PLAN REVIEW SHEET

Date: December 15, 2020

Petition #: RZP 2020-178

Request: MUDD-O (SPA)

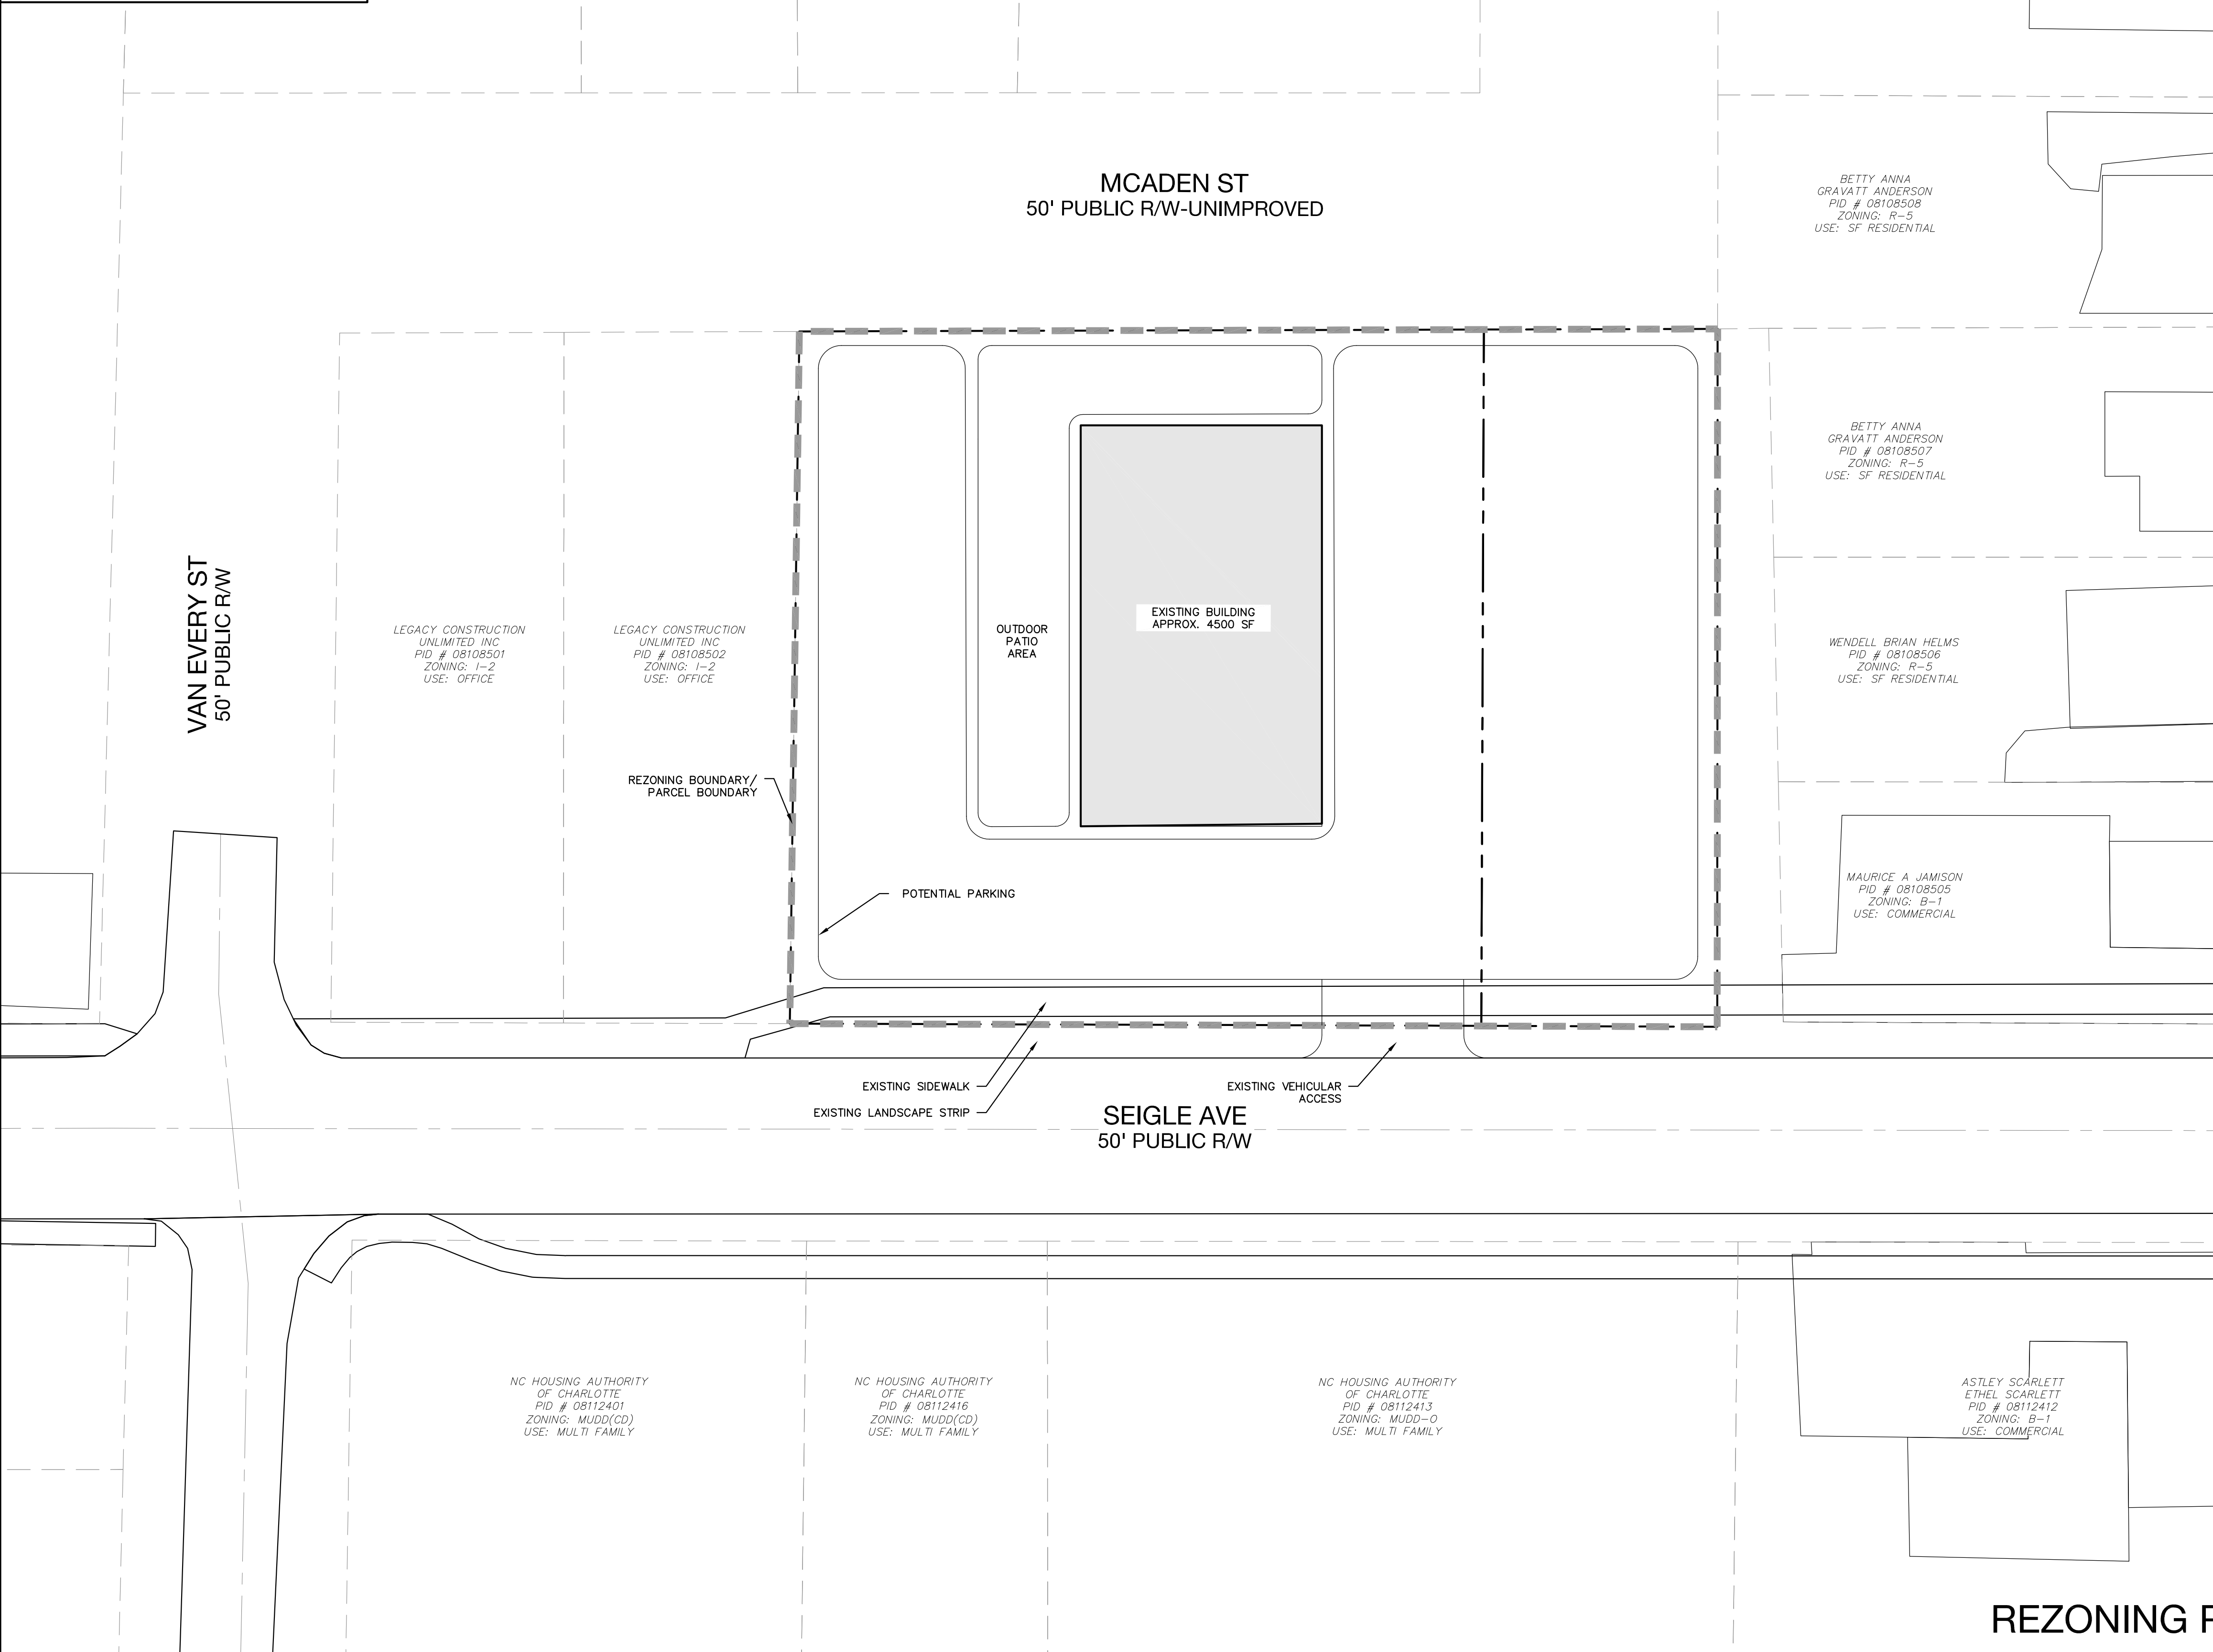
The site is located along CATS local bus route #4 on Seigle Avenue. CATS requests the petitioner to construct a new ADA compliant bus waiting pad per Land Development Standard 60.01B along Seigle Avenue for inbound stop #26890. The final location of the pad will be coordinated with the developer through the permitting process.
